# CITY OF ALBUQUERQUE

July 26, 2017

**RE: Sawmill Village Phase 2  
Grading Plan  
Stamp Date: 7/24/17  
Hydrology File: H13D025A**

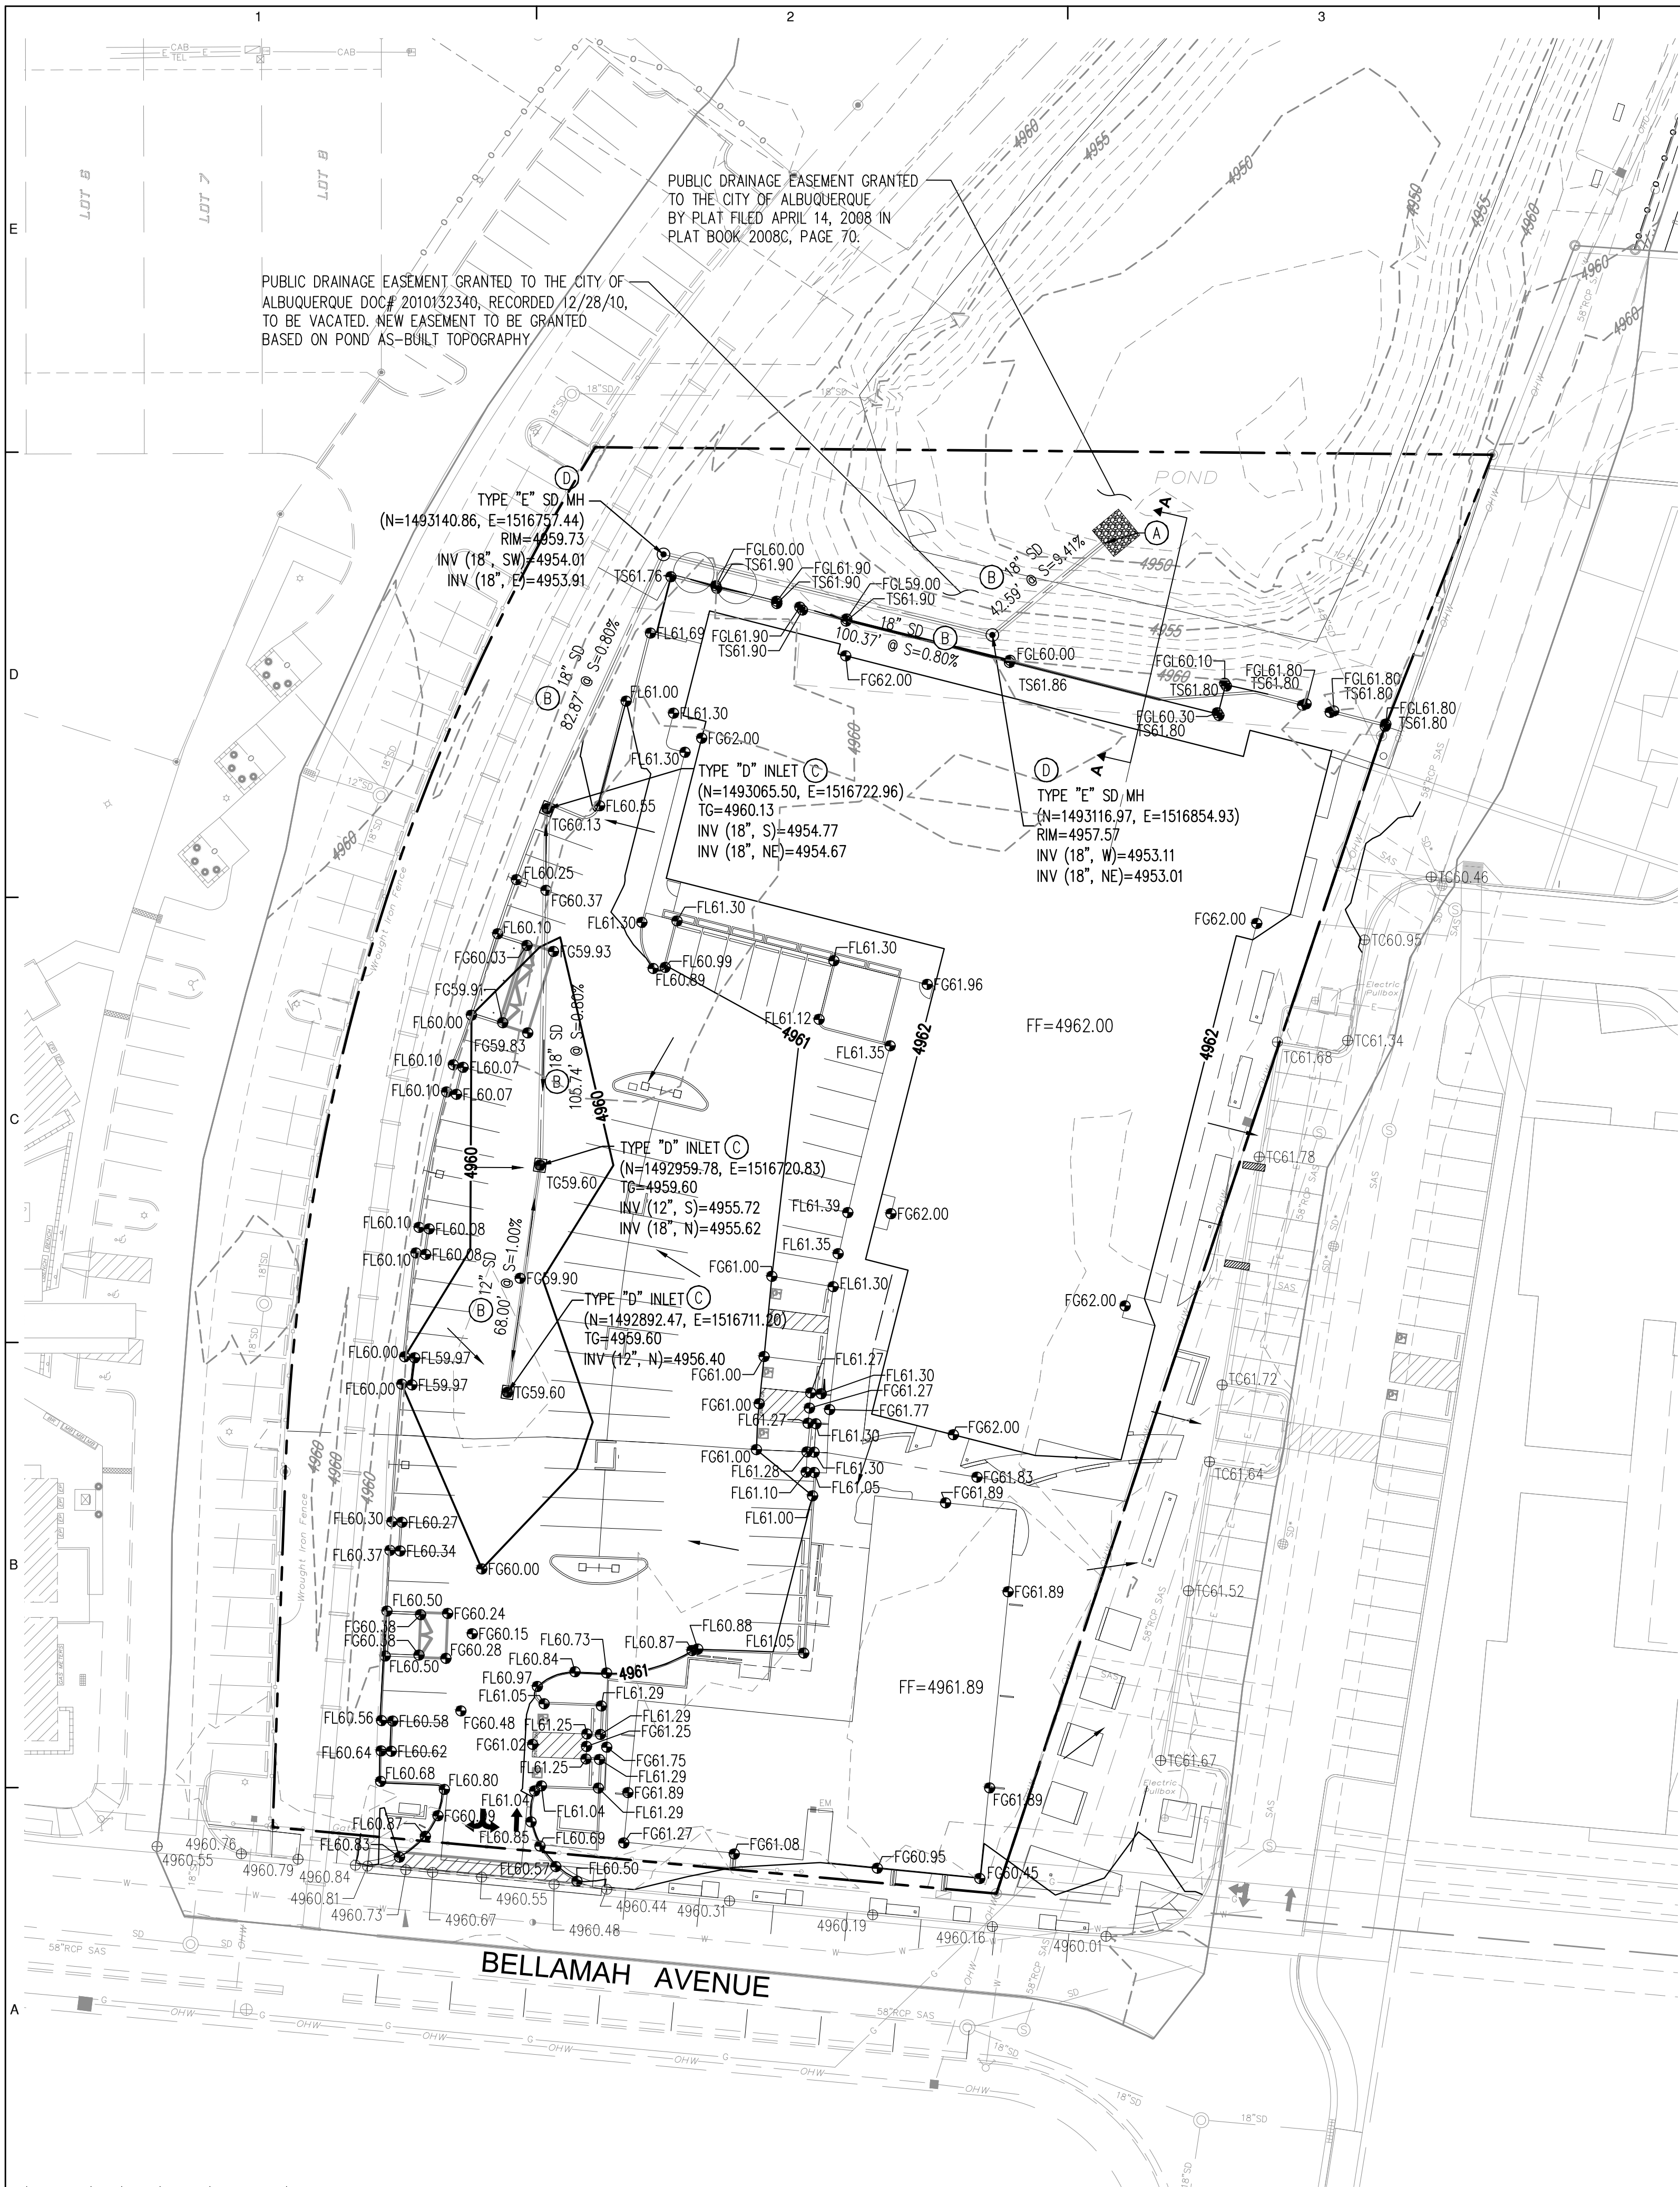
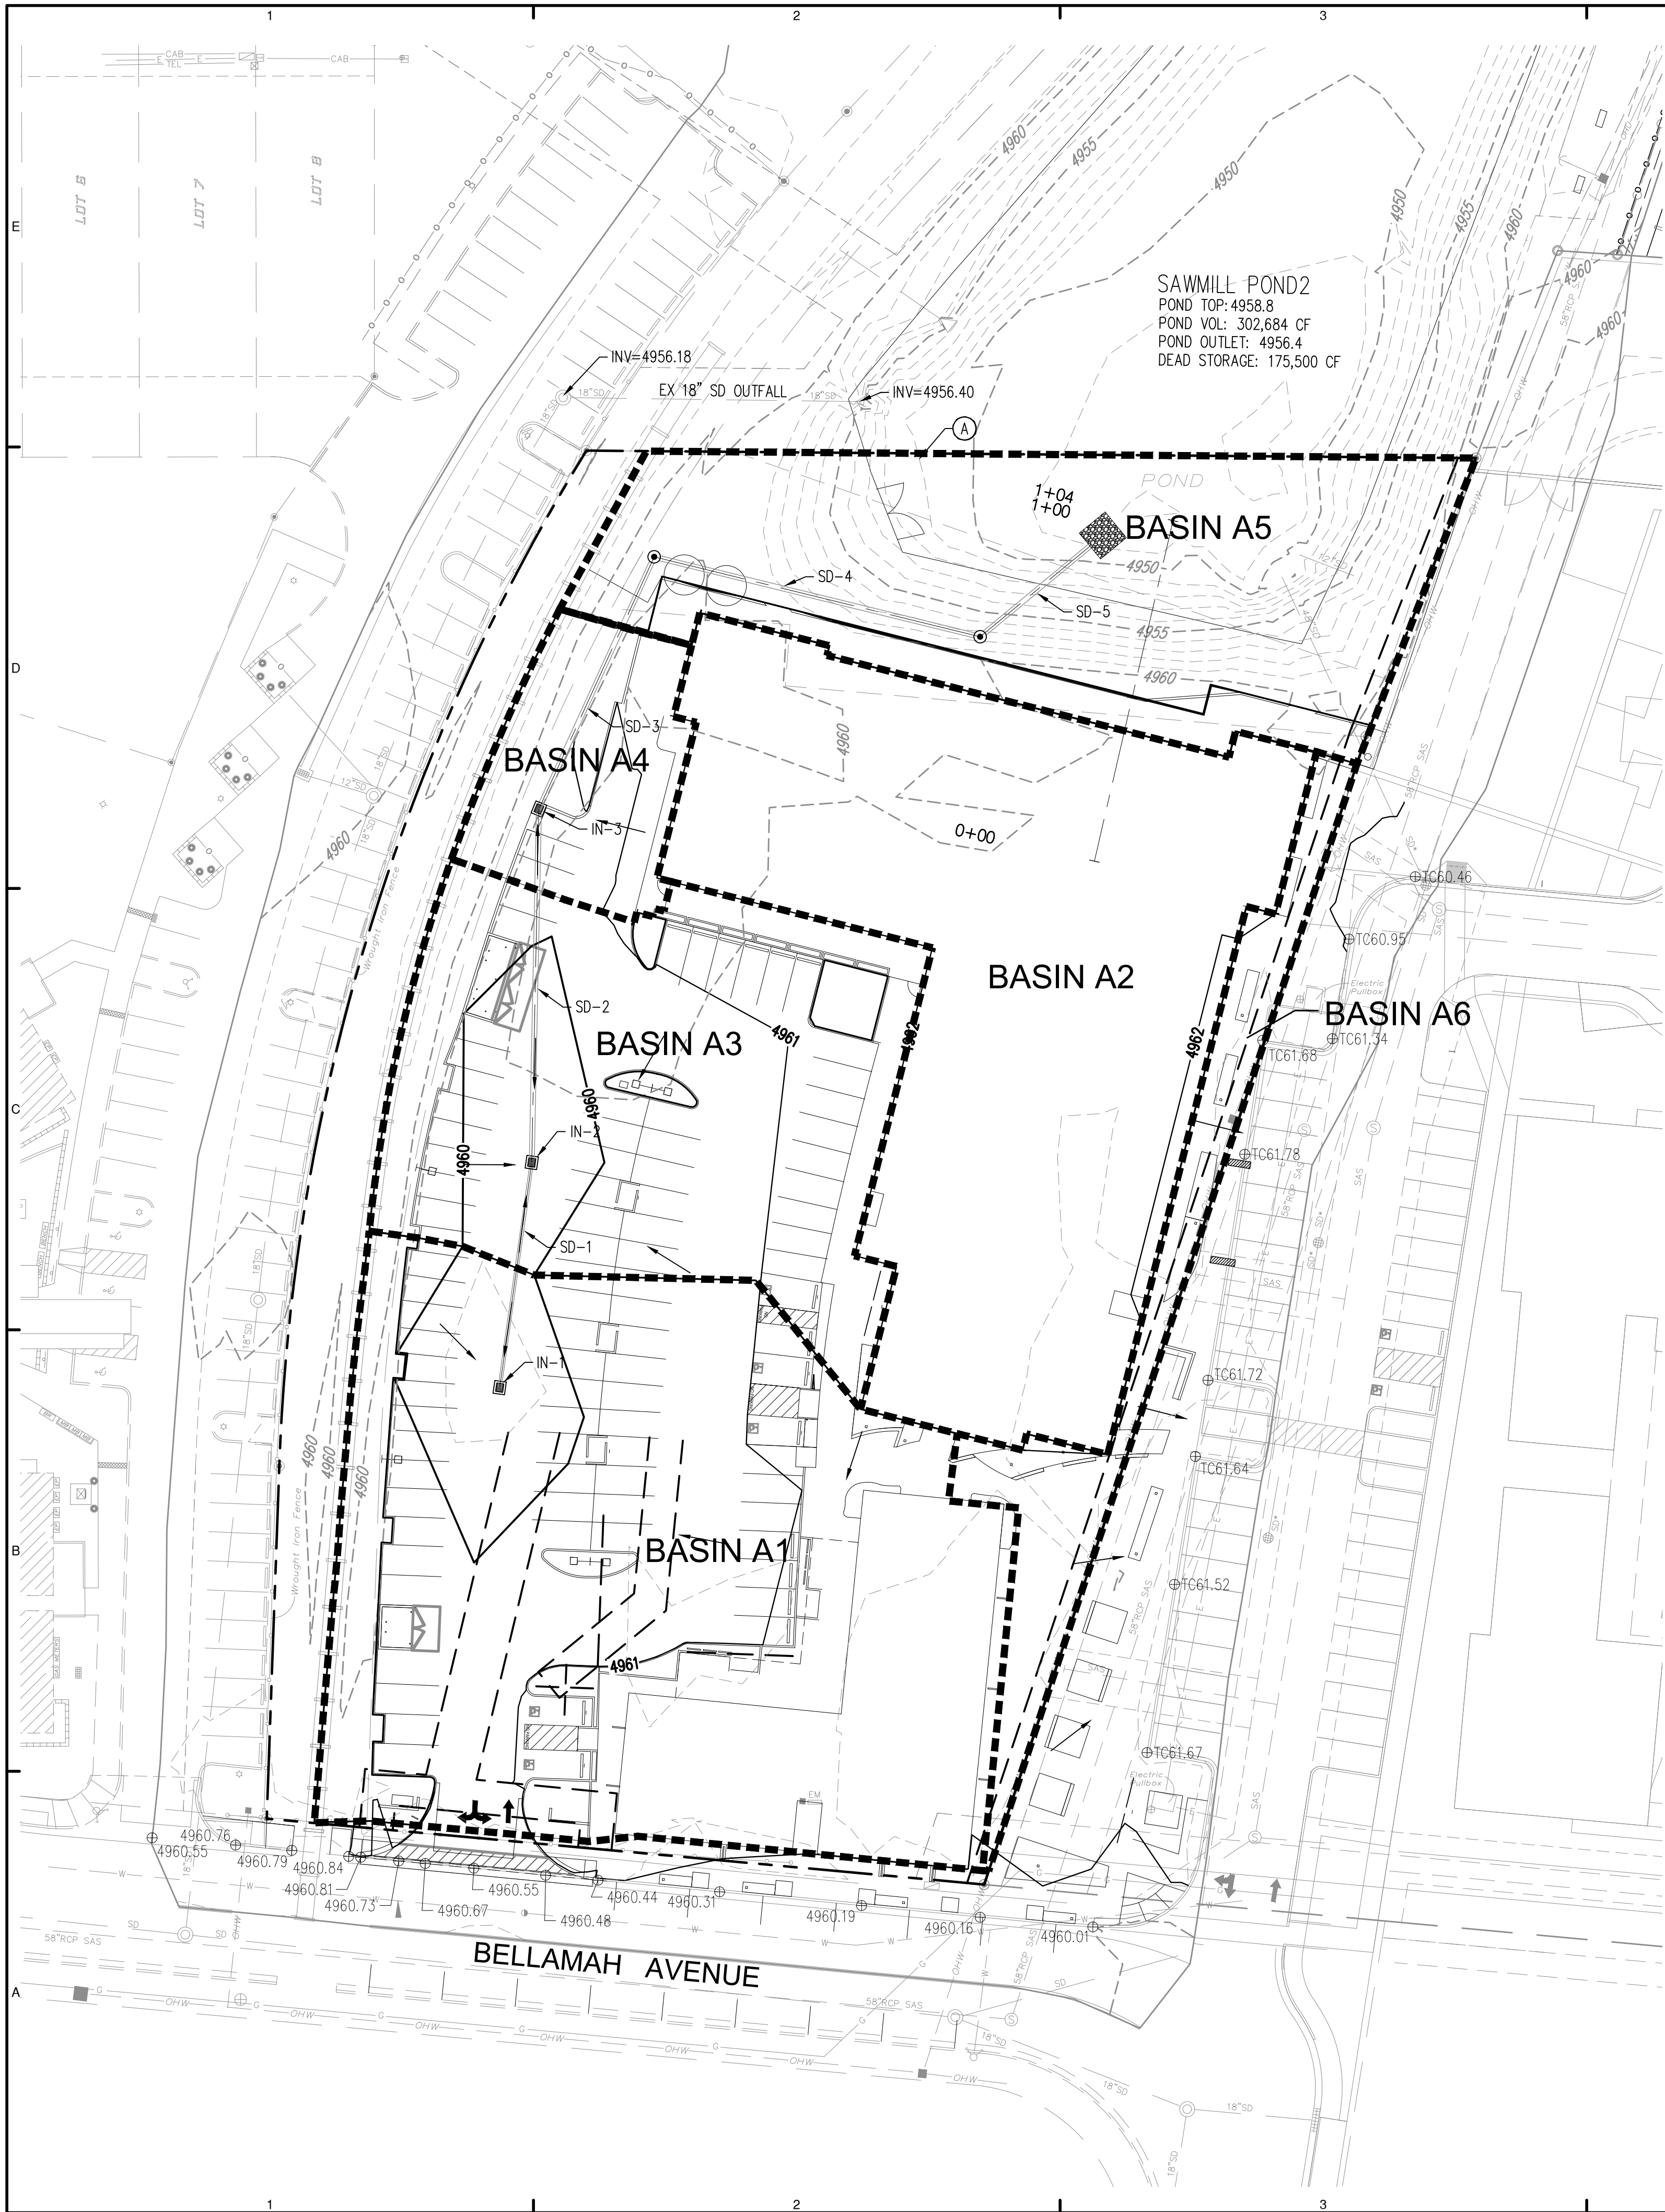
1. Please provide the required 0.87' water block per COA Paving Detail No. 2426.
2. Please provide the three point chart for each driveway radius per COA Paving Detail No. 2426.
3. Please provide a section through the proposed building and existing adjacent pond. Please label the elevations of the top of pond, the bottom of pond and the 100 year WSE.
